# CITY OF ALBUQUERQUE

**Re: CVS Pharmacy @ Central & Louisiana, 7105 Central Ave NE,  
Permanent Certificate of Occupancy - Approved  
Engineer's Stamp dated 6-03-09 (K-19/D141)  
Certification dated 1-12-10**

**Re: CVS Pharmacy, NE corner of Central and Louisiana, Grading and Drainage Plan**

**Re: CVS Pharmacy, NE corner of Central and Louisiana, Grading and Drainage Plan**

C201

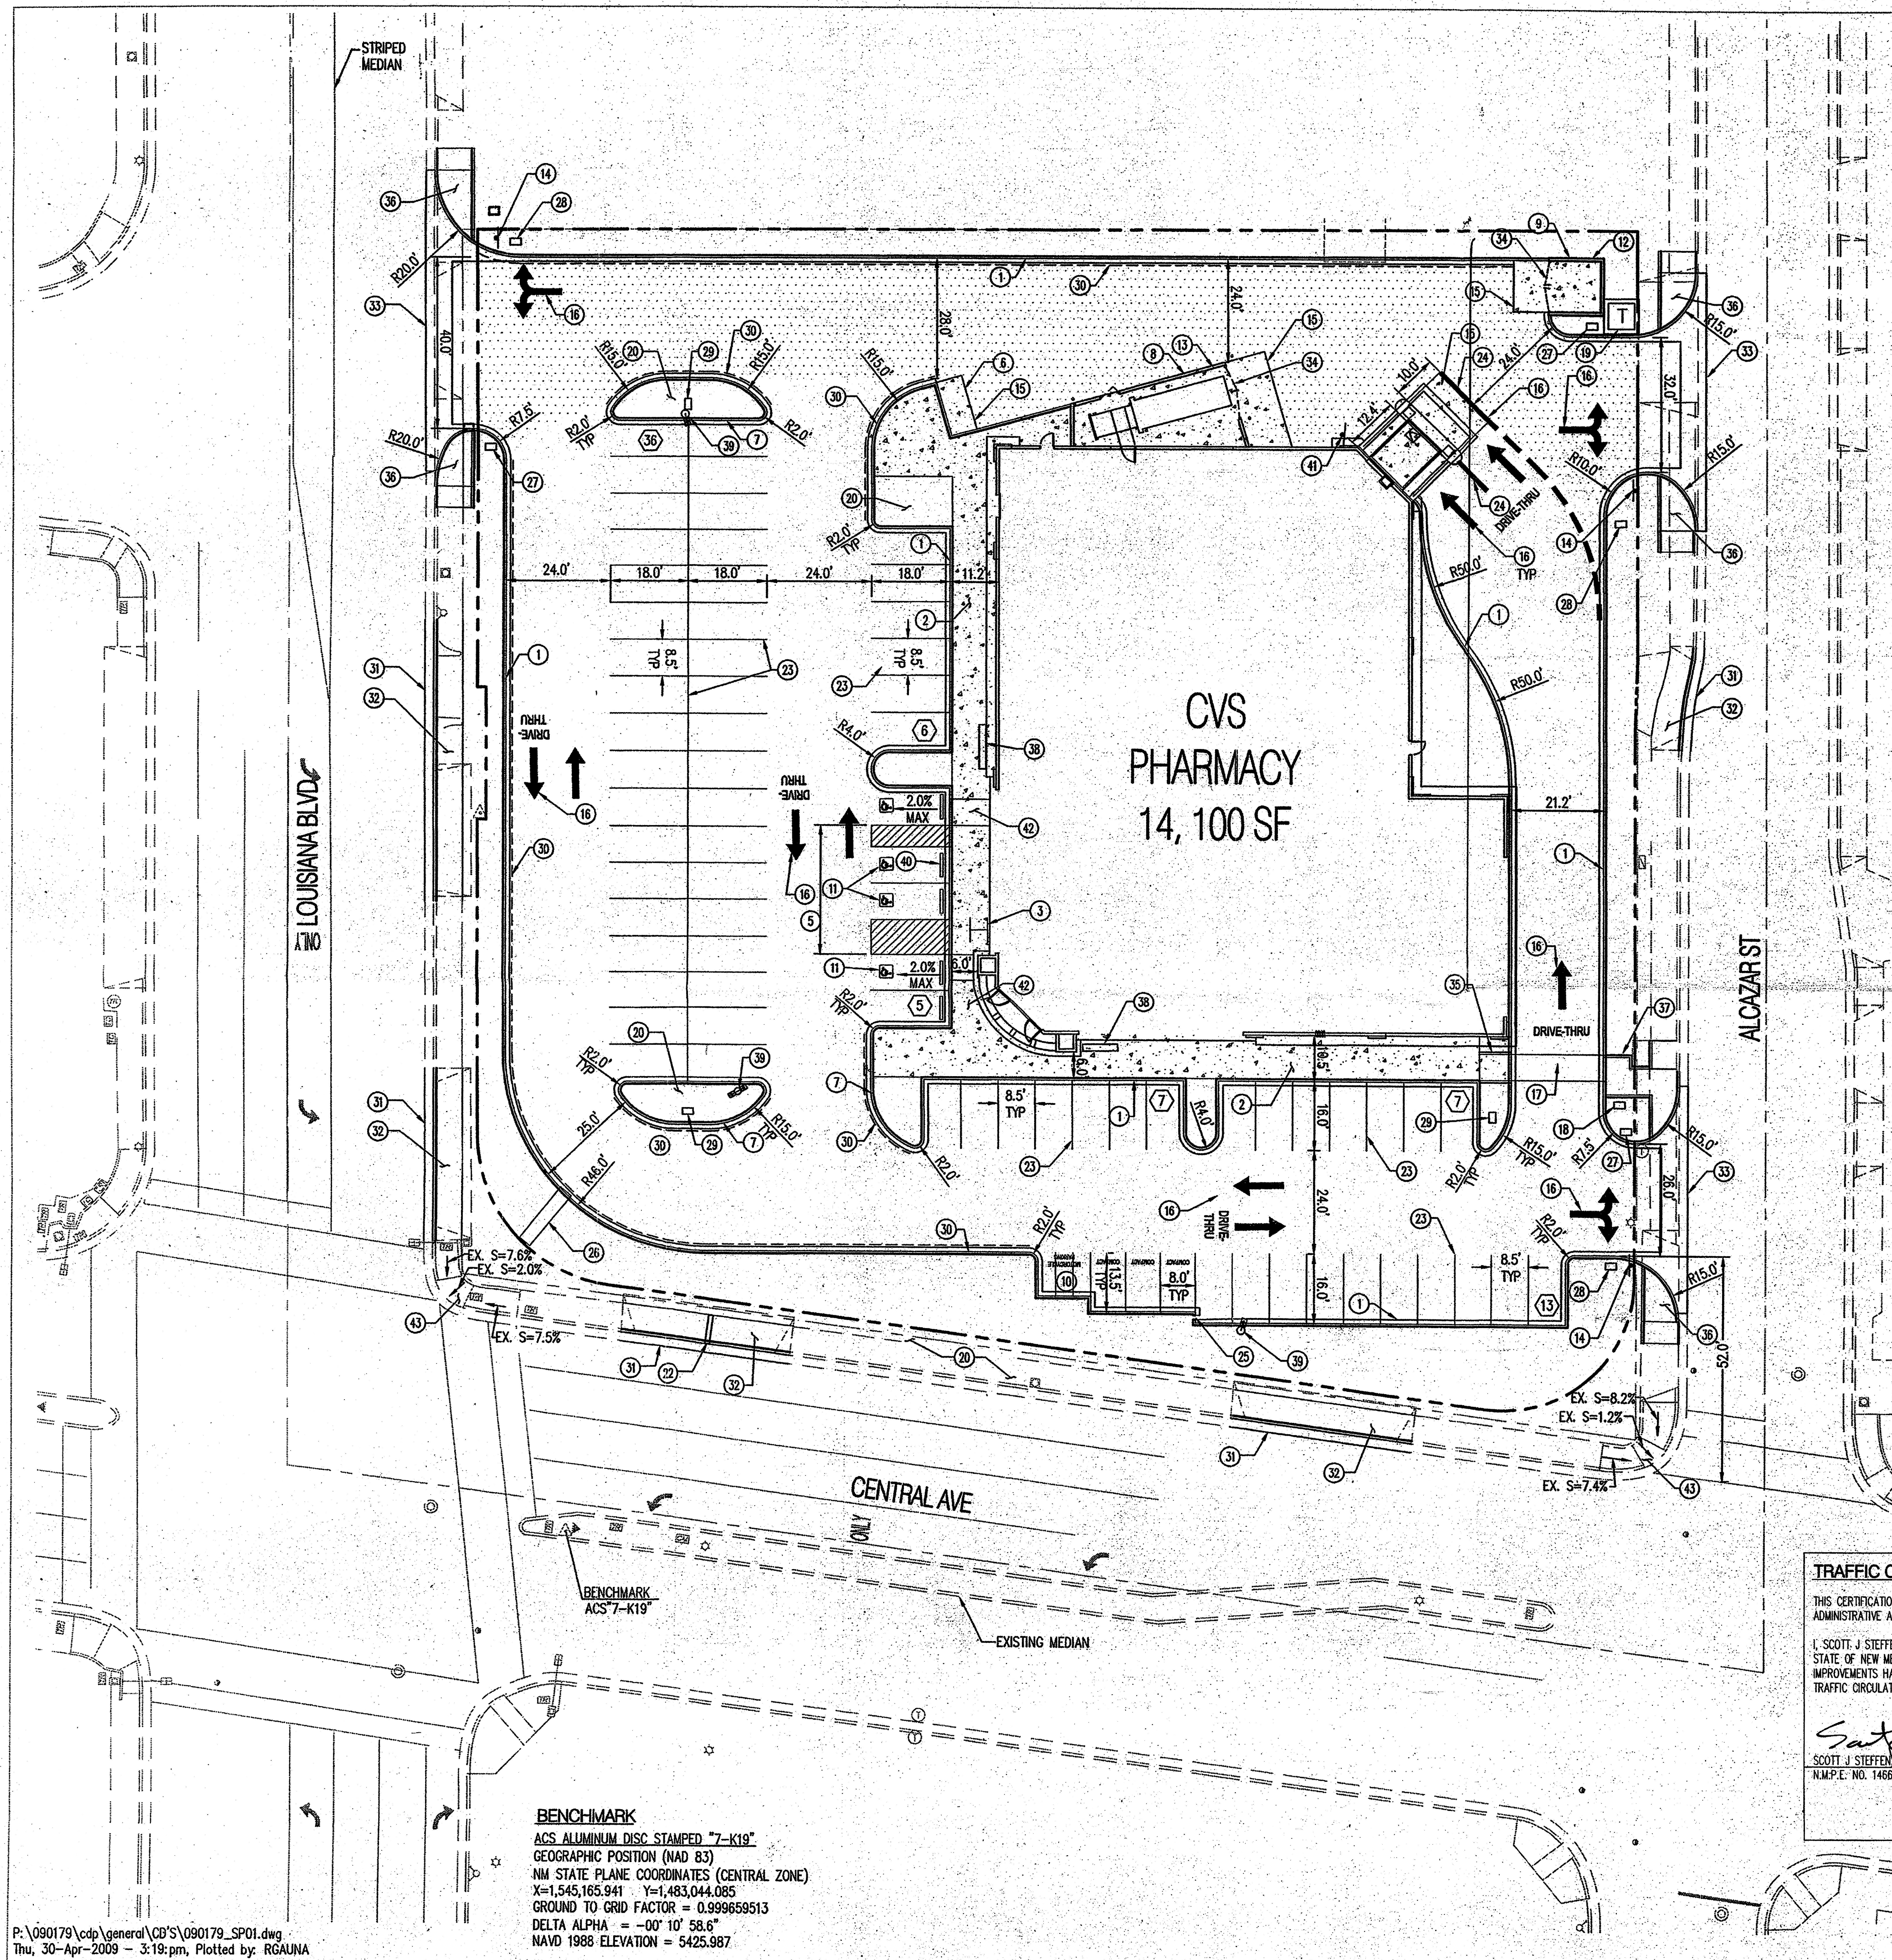
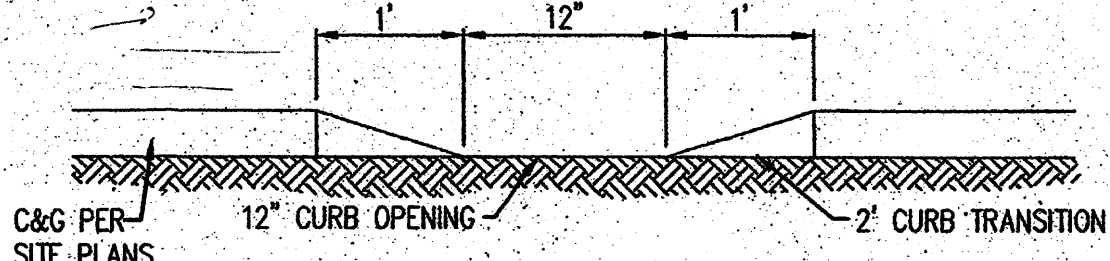
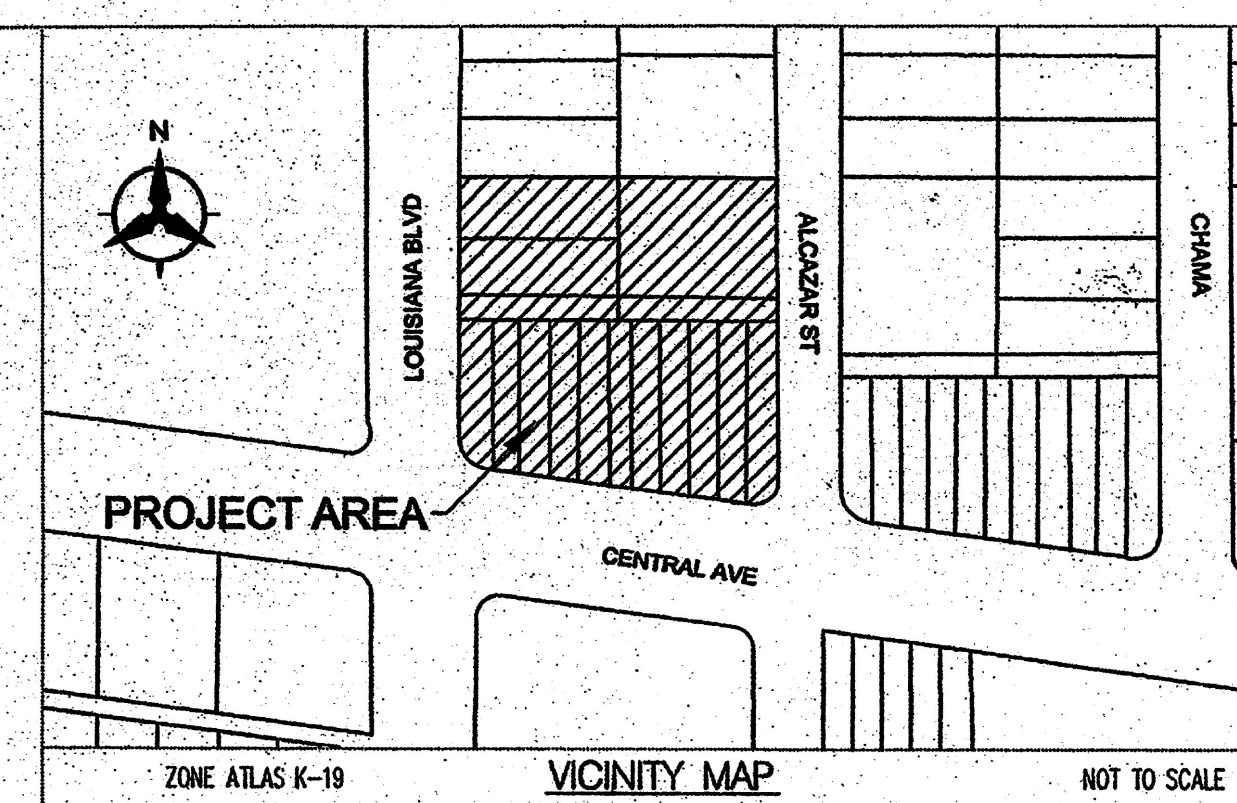
- Per COA STD DWG 2236, the sidewalk culvert must extend to the property line. Show it this way on the Grading Plan and change the upstream invert, if necessary. I realize the back of sidewalk is not at the property line.

Please provide 2 copies of Sheet C201, as we give one to the inspector.
